CBP 2,7-1  
1716 GARY WATSON POINT  
COLORADO SPRINGS, CO 80915  
EL PASO COUNTY, COLORADO

# Site Development Plan\_V1.pdf Markup Summary

PCD File No. PPR2030

1 of 12  
SITE PLAN

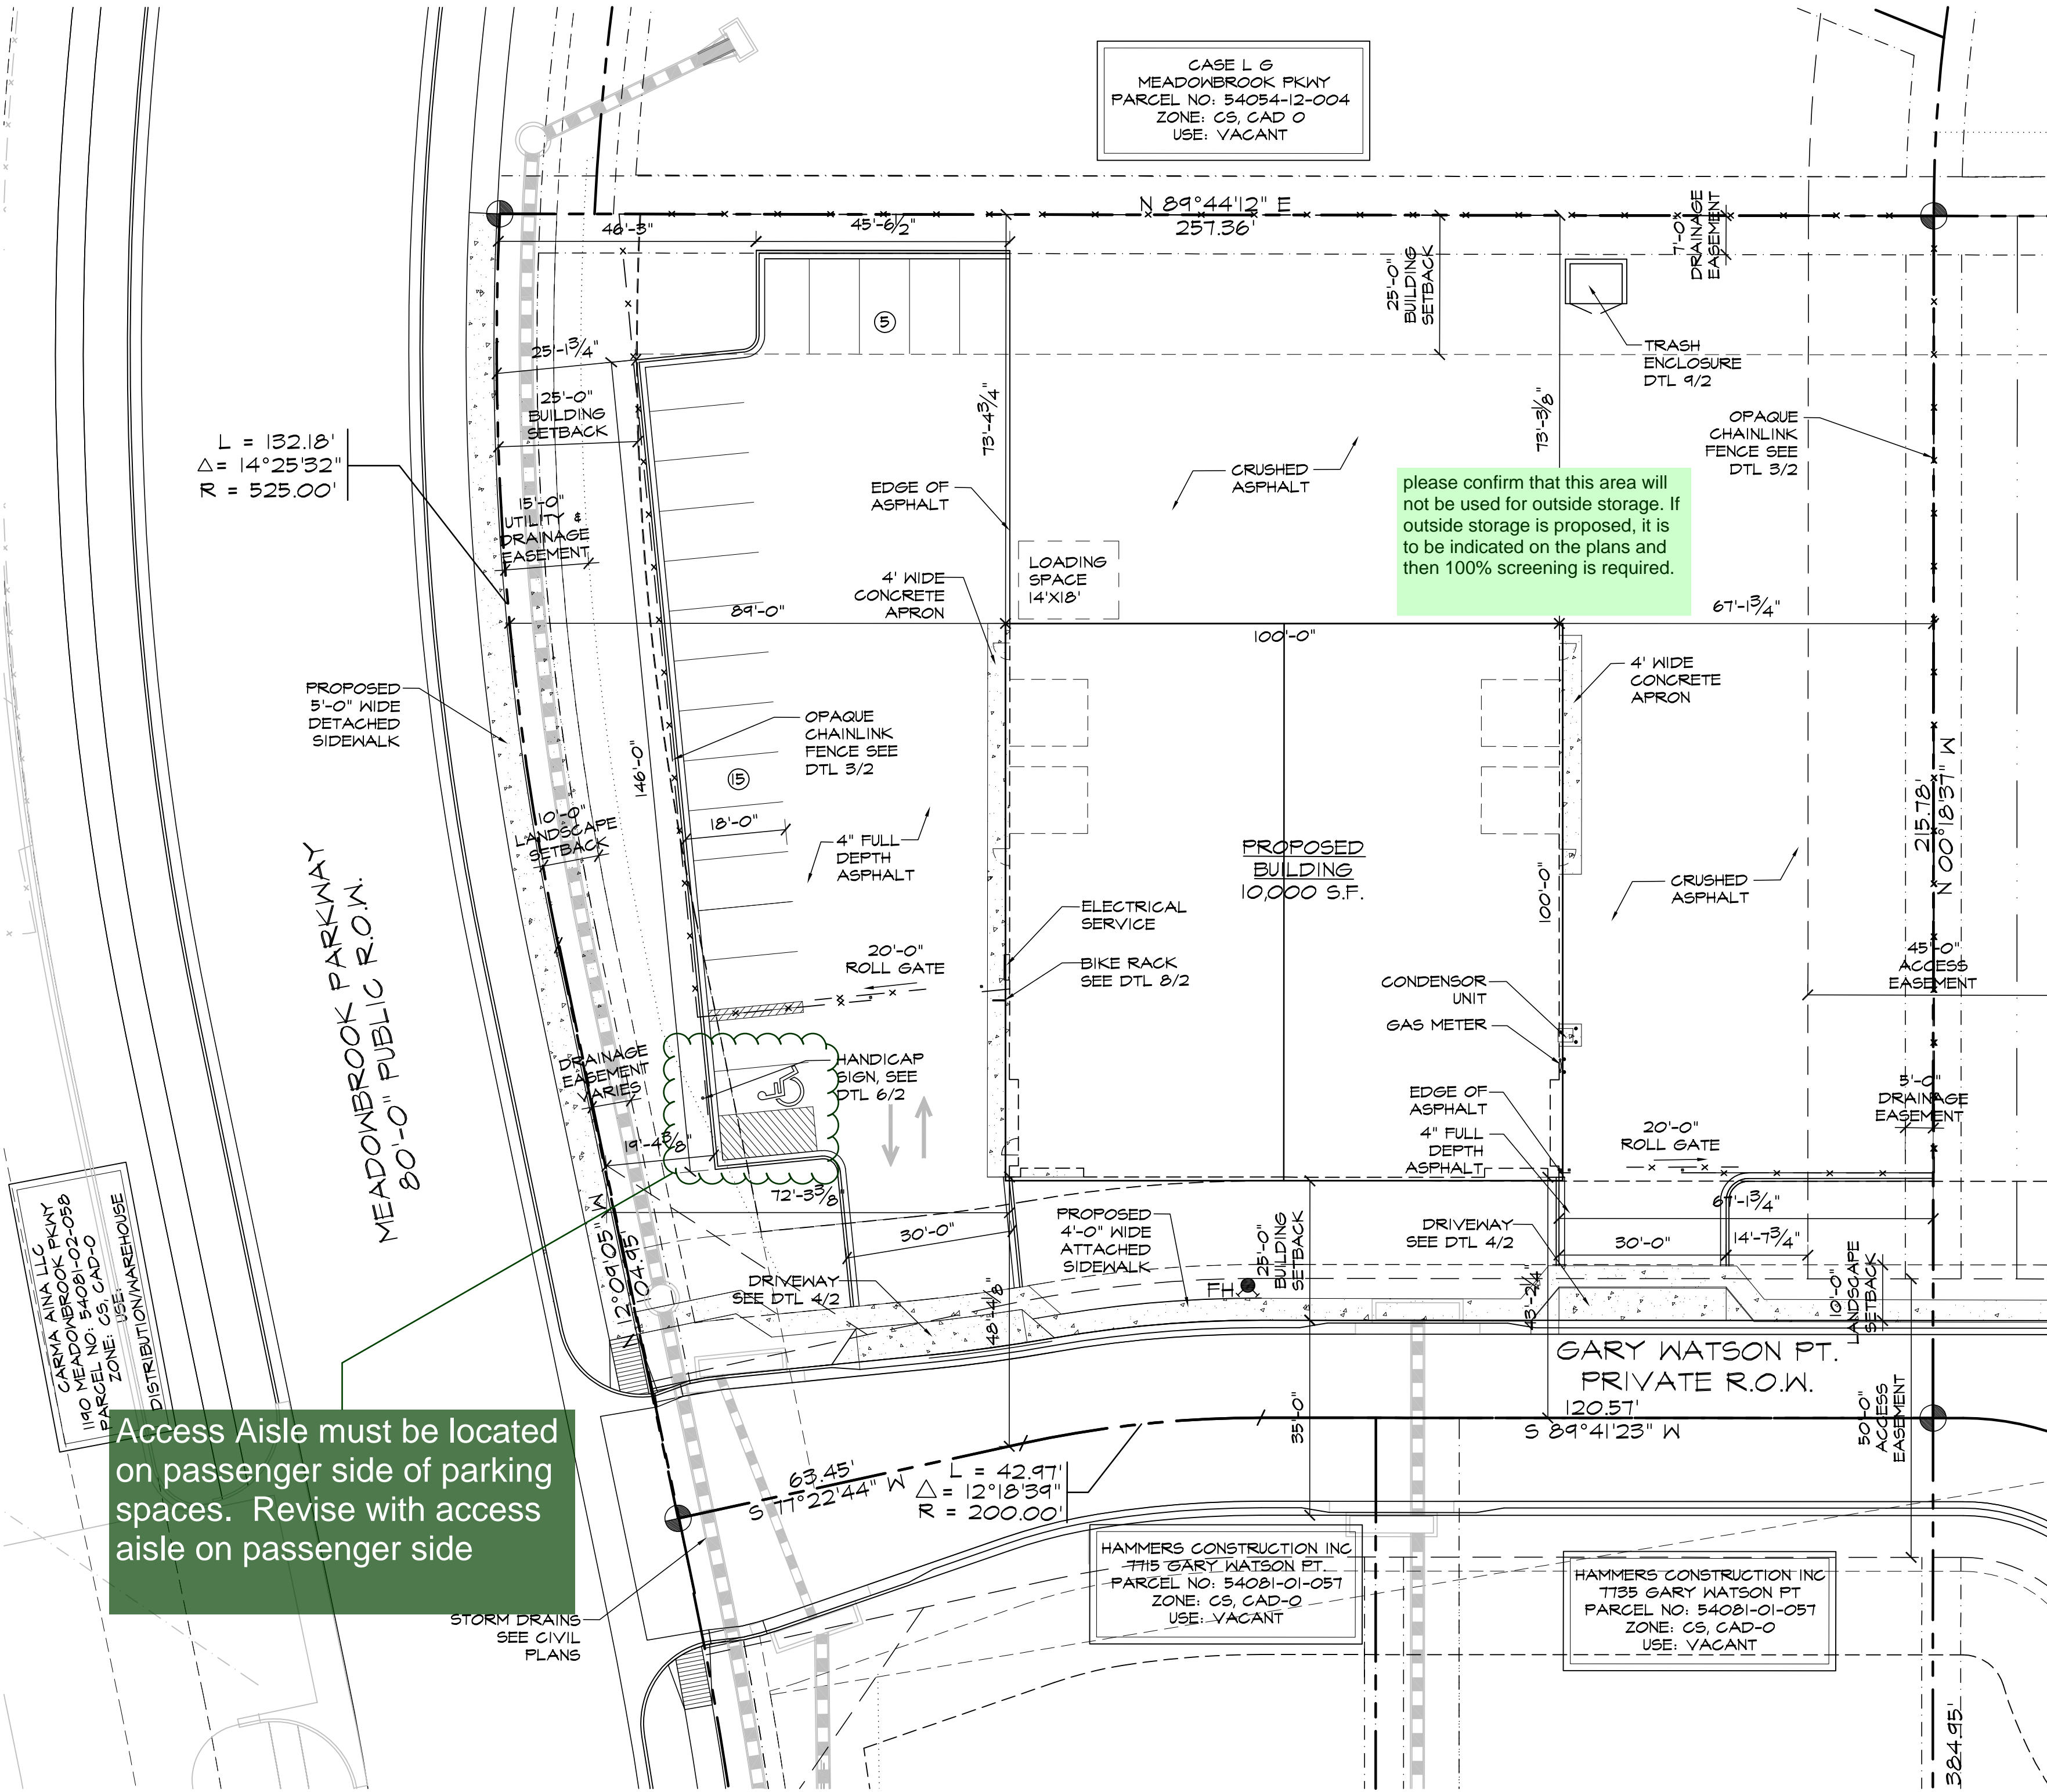
Access Aisle must be located on passenger side of parking spaces. Revise with access aisle on passenger side

- 1) Show existing and proposed topography.
- 2) Show the location of all existing and proposed utilities on the site or in the adjacent ROW.

FYI per ADA criteria, sidewalks should go around drive apron (ECM CH 6).

to include all easements.
